MEMORANDUM

SUBJECT: SP-20-008 – Homestead North - Sterling Ranch
Second Submittal

Engineering Division

UNTIL SUCH TIME AS  
THESE DRAWINGS ARE  
APPROVED BY THE  
APPROPRIATE REVIEWING  
AGENCIES, JR ENGINEERING  
ACCEPTS NO LIABILITY  
ONLY FOR THE PURPOSES  
DESIGNATED BY WRITTEN  
AUTHORIZATION.

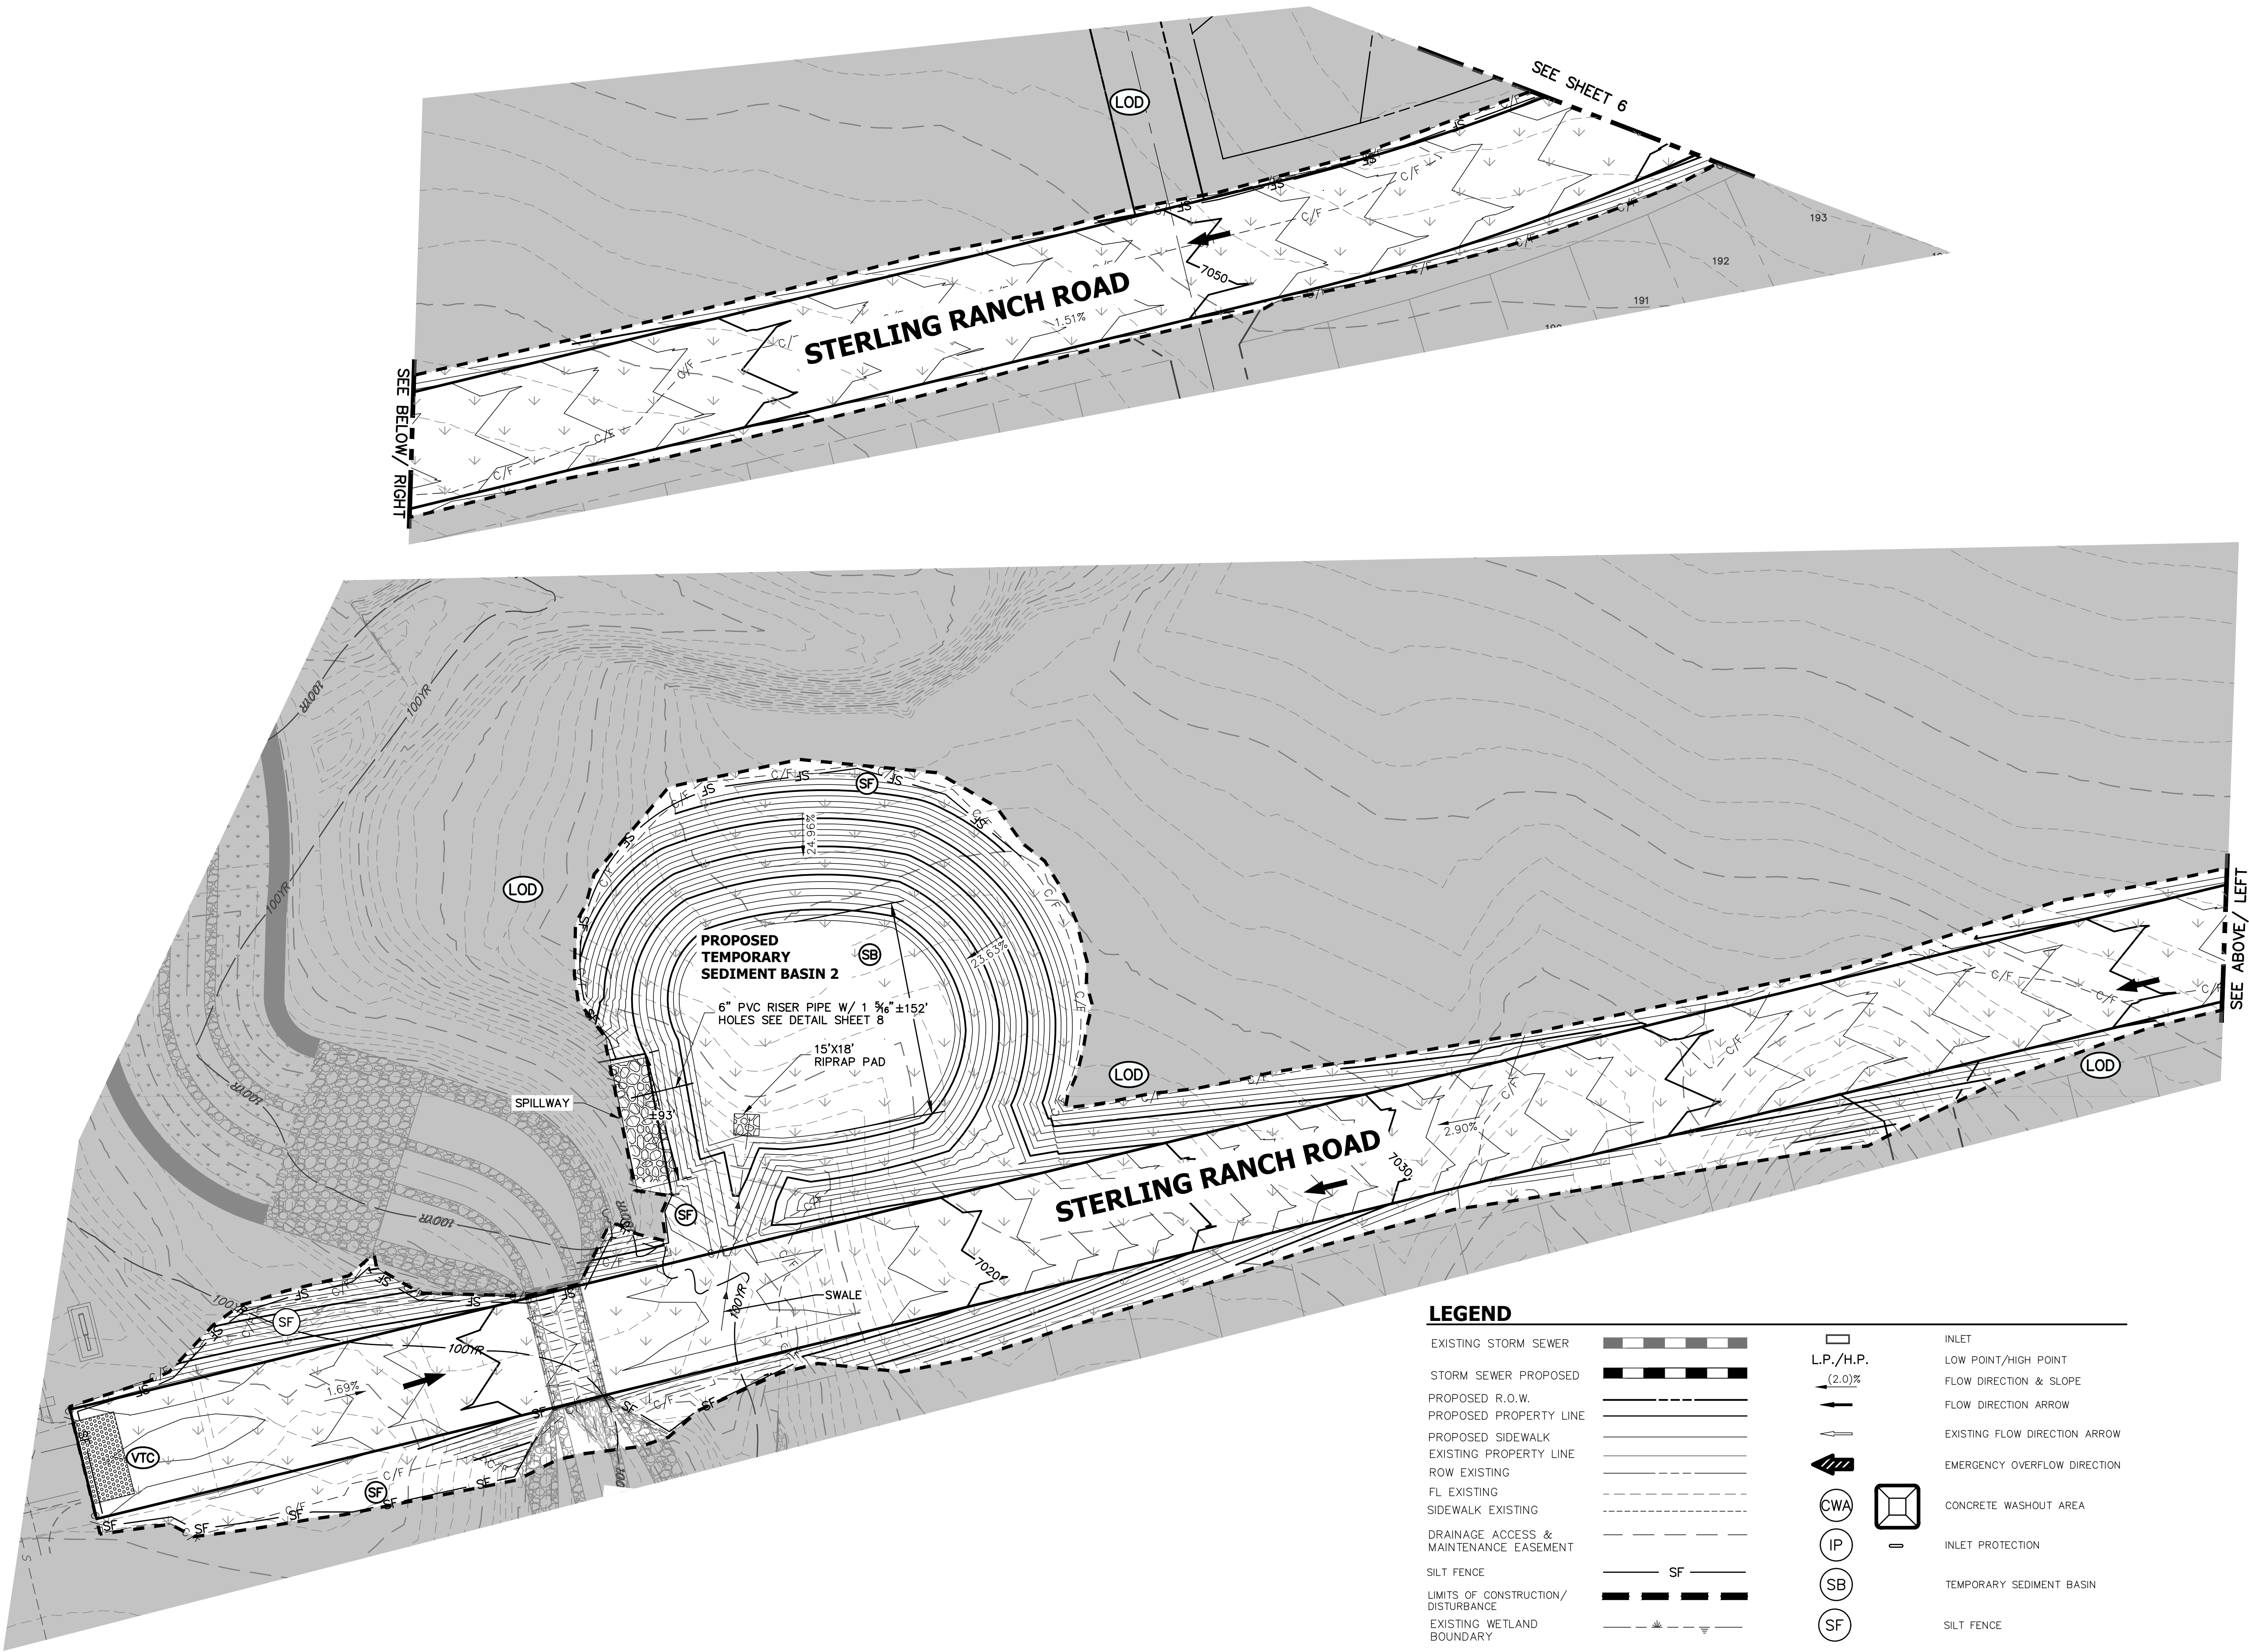
- 6. Note: **not all** inlet and storm drain calculations were checked in detail with this review.
- 7. Also provide a drainage plan for the interim pre-development site grading not showing curb and gutter and showing temporary facilities. This should match the grading shown on the early grading and erosion control plan. **Partially resolved; see redlines.**

- a. **Note: this submittal of the GEC plan was not reviewed by PCD-Engineering pending revisions to the PDR and preliminary plan and review of the revised Sand Creek channel plans.**
 - b. **Address how the potentially unstable areas along Sand Creek at the northeast corner of the site will be stabilized.**
2. The maintenance access road shown along the west side of the channel runs in and out of the grading area. This road needs to be completed to criteria (slope, width, etc.) with the site grading to avoid regrading stabilized areas next to the channel. It needs to avoid future wetland mitigation areas and unstable areas. **(see related comments above and PDR redlines)**
